Item No. **Report of the Head of Development Management and Building Control**

Address: 35 COPPERFIELD AVENUE HILLINGDON

Development: Erection of outbuilding to rear garden for use as annex.

LBH Ref Nos: 22078/APP/2025/1112

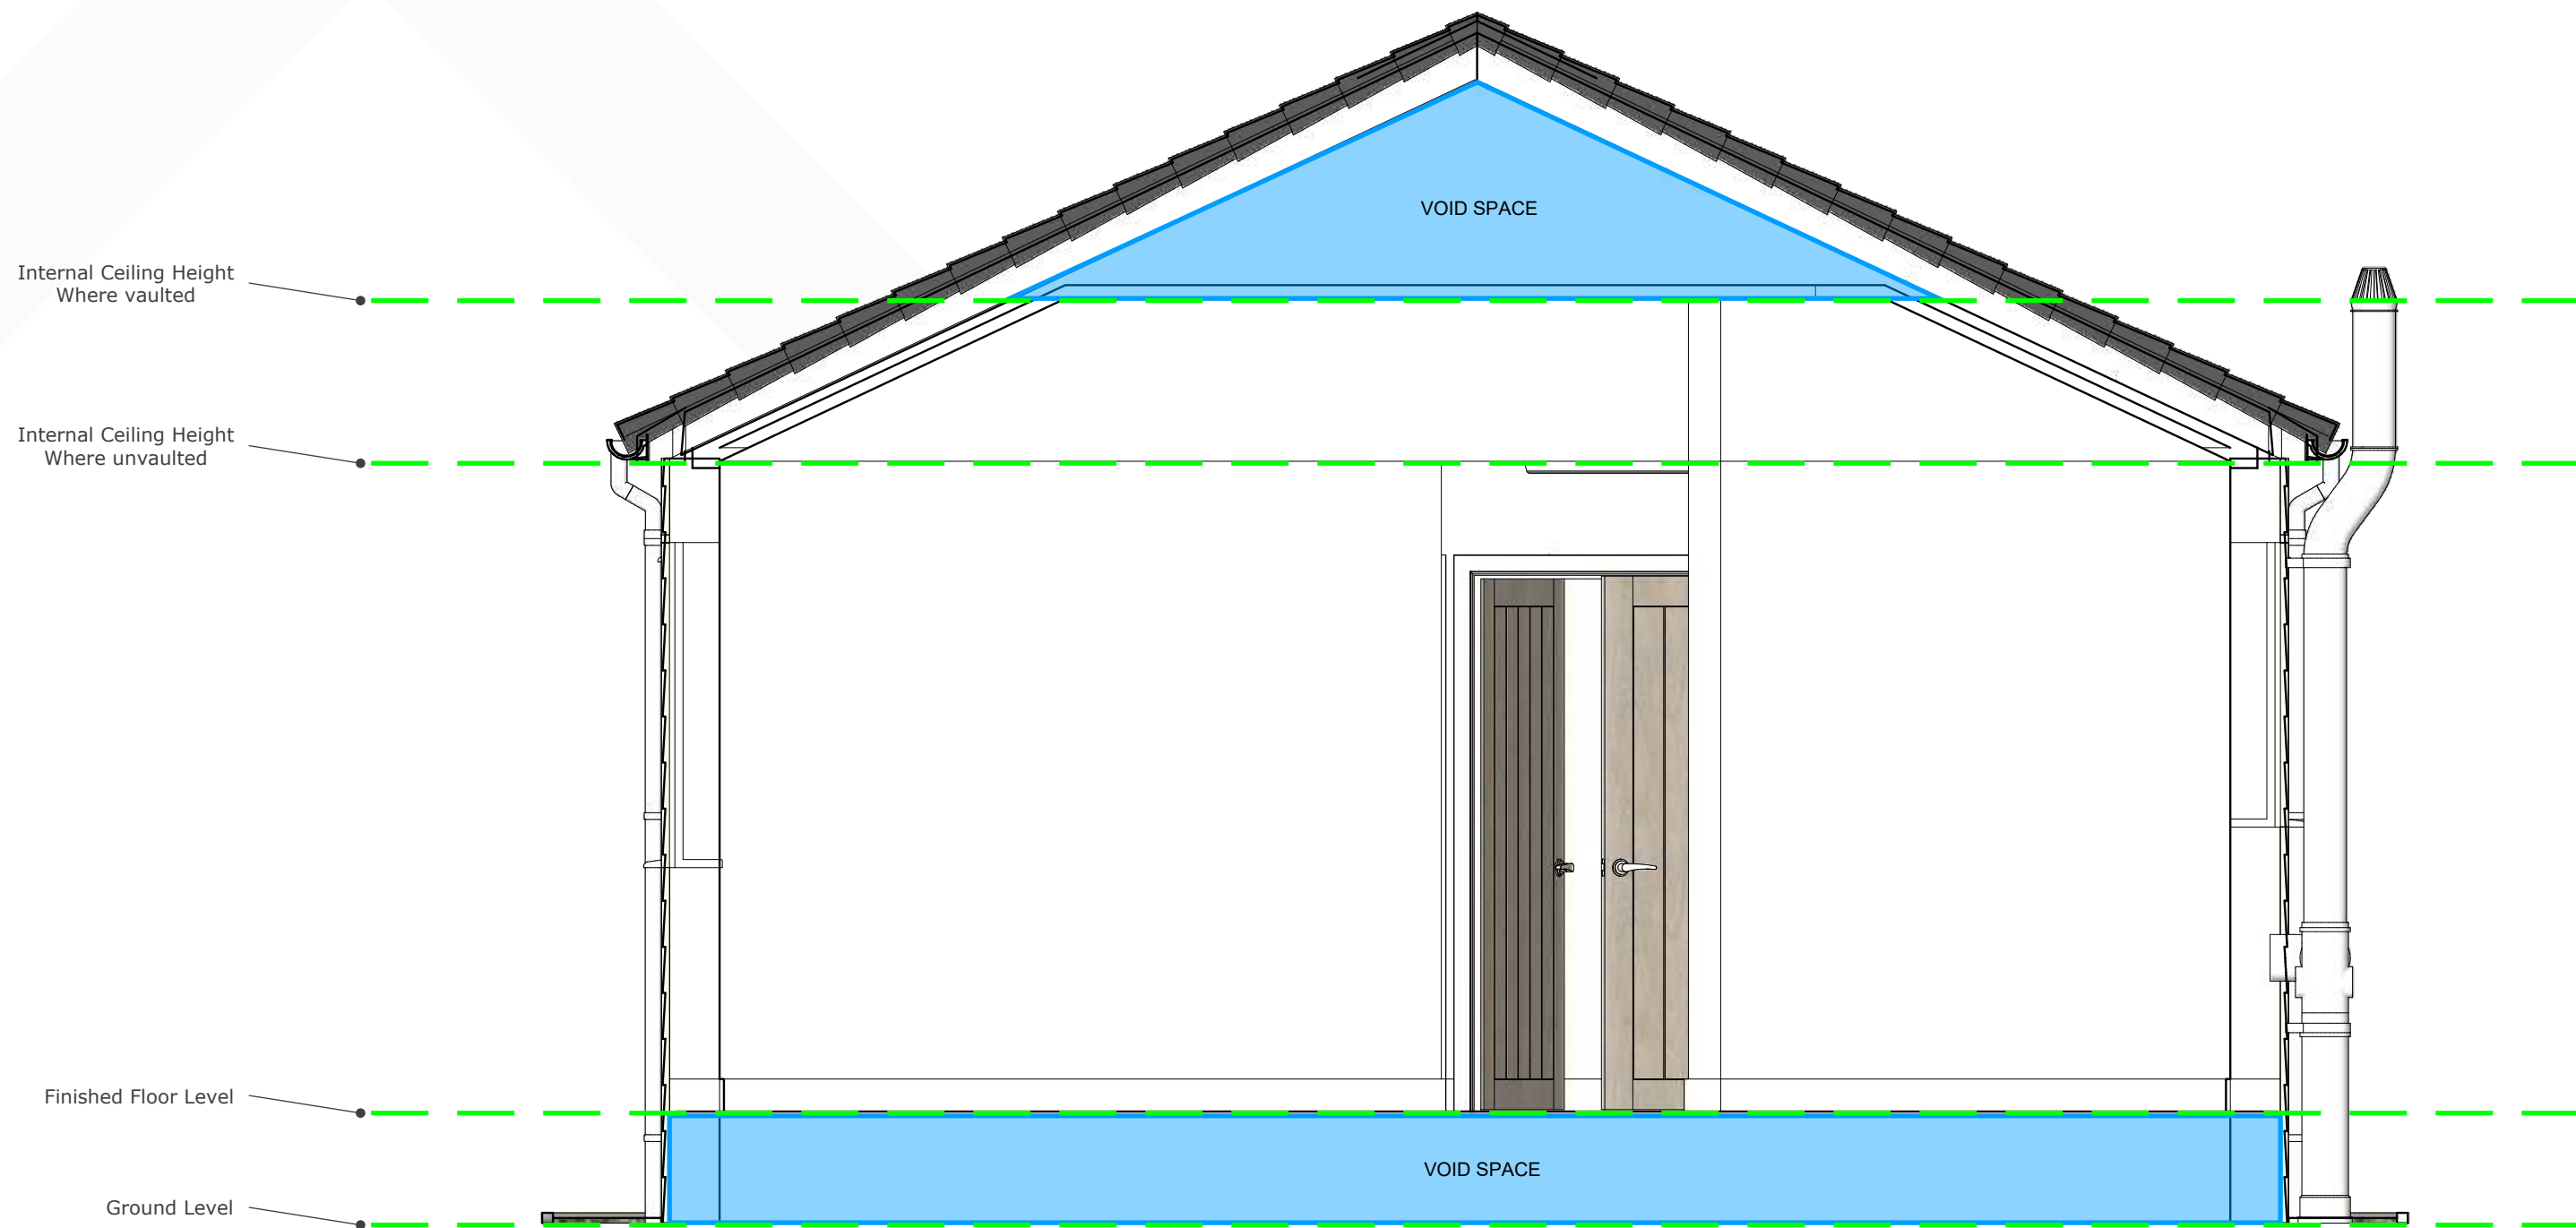
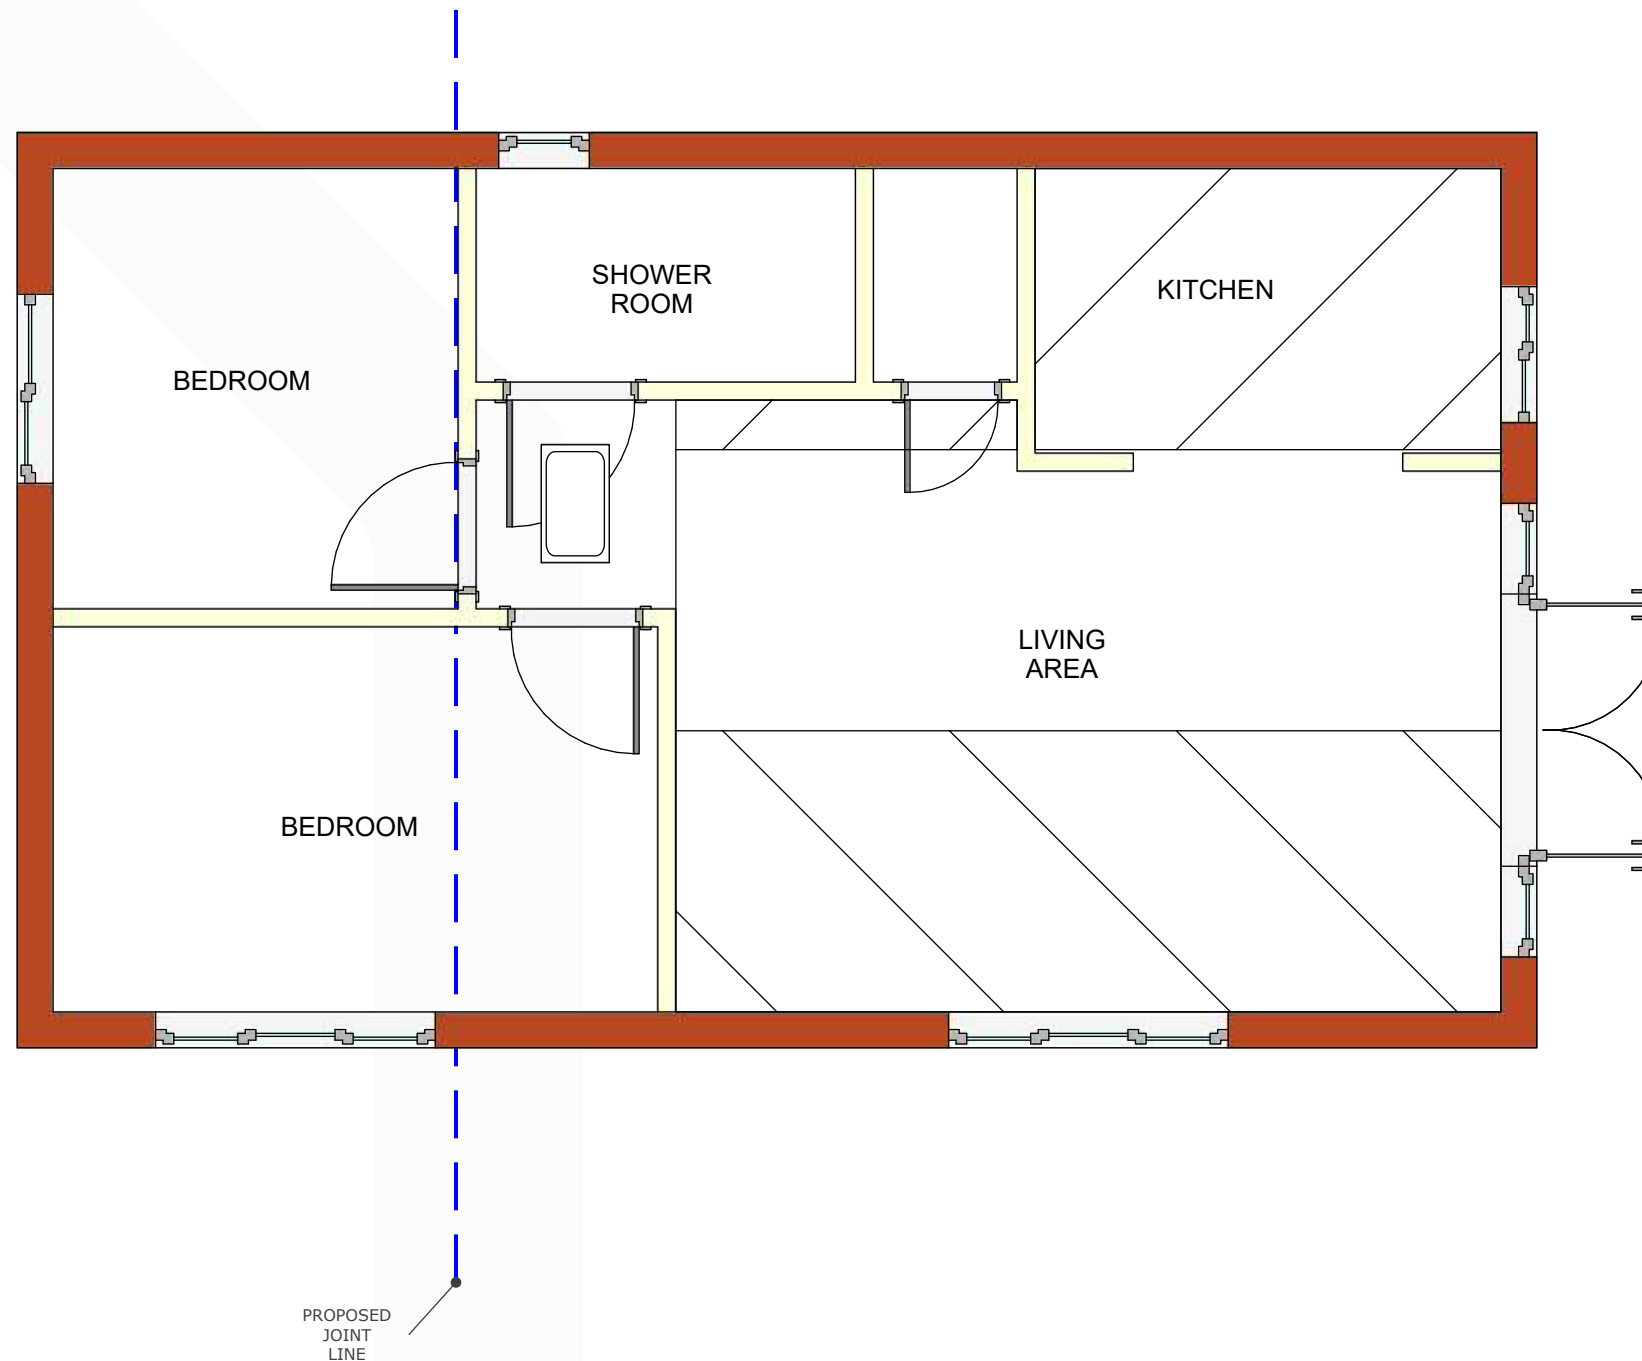
The submitted plans indicate the provision of a living room, kitchen, bathroom and two bedrooms within the 60 square metre outbuilding. The applicant has advised that the proposal seeks to erect an annexe to provide ancillary accommodation for the applicant, who, due to advancing age and declining health, requires an increasing level of care and support from his family. The applicant has advised that the annexe is essential to fulfil the care and support needs of the applicant, and the family is committed to addressing day-to-day requirements such as cooking, socialising, laundry, errands, appointments, and overall support.

Officers however consider that, despite this, it is considered that, on the balance of probability, the building (if situated in the proposed location) could be accessed from Colham Road, within the street scene there are already multiple examples of dwellings with separate rear entrances to the garden via Colham Road such as the adjoining neighbours at Nos.33 and 37 Copperfield Avenue. Given the kitchen/living room, bathroom facilities and 2 separate rooms (capable of being used as bedrooms) shown on the submitted plans, it is considered that on the balance of probability, the unit could be occupied separately to the main dwelling, and would be capable of use as a independent dwelling.

The proposed development, by reason of the provision of facilities within the proposed outbuilding, the size of the outbuilding and independent access to the proposed outbuilding, is considered capable of independent occupation from the main dwelling. As a result, the proposal would be tantamount to a separate self-contained residential unit in a position where such a dwelling would be unacceptable. Consequently, the proposed development would harm the character and appearance of the area and the amenity of neighbouring residents.
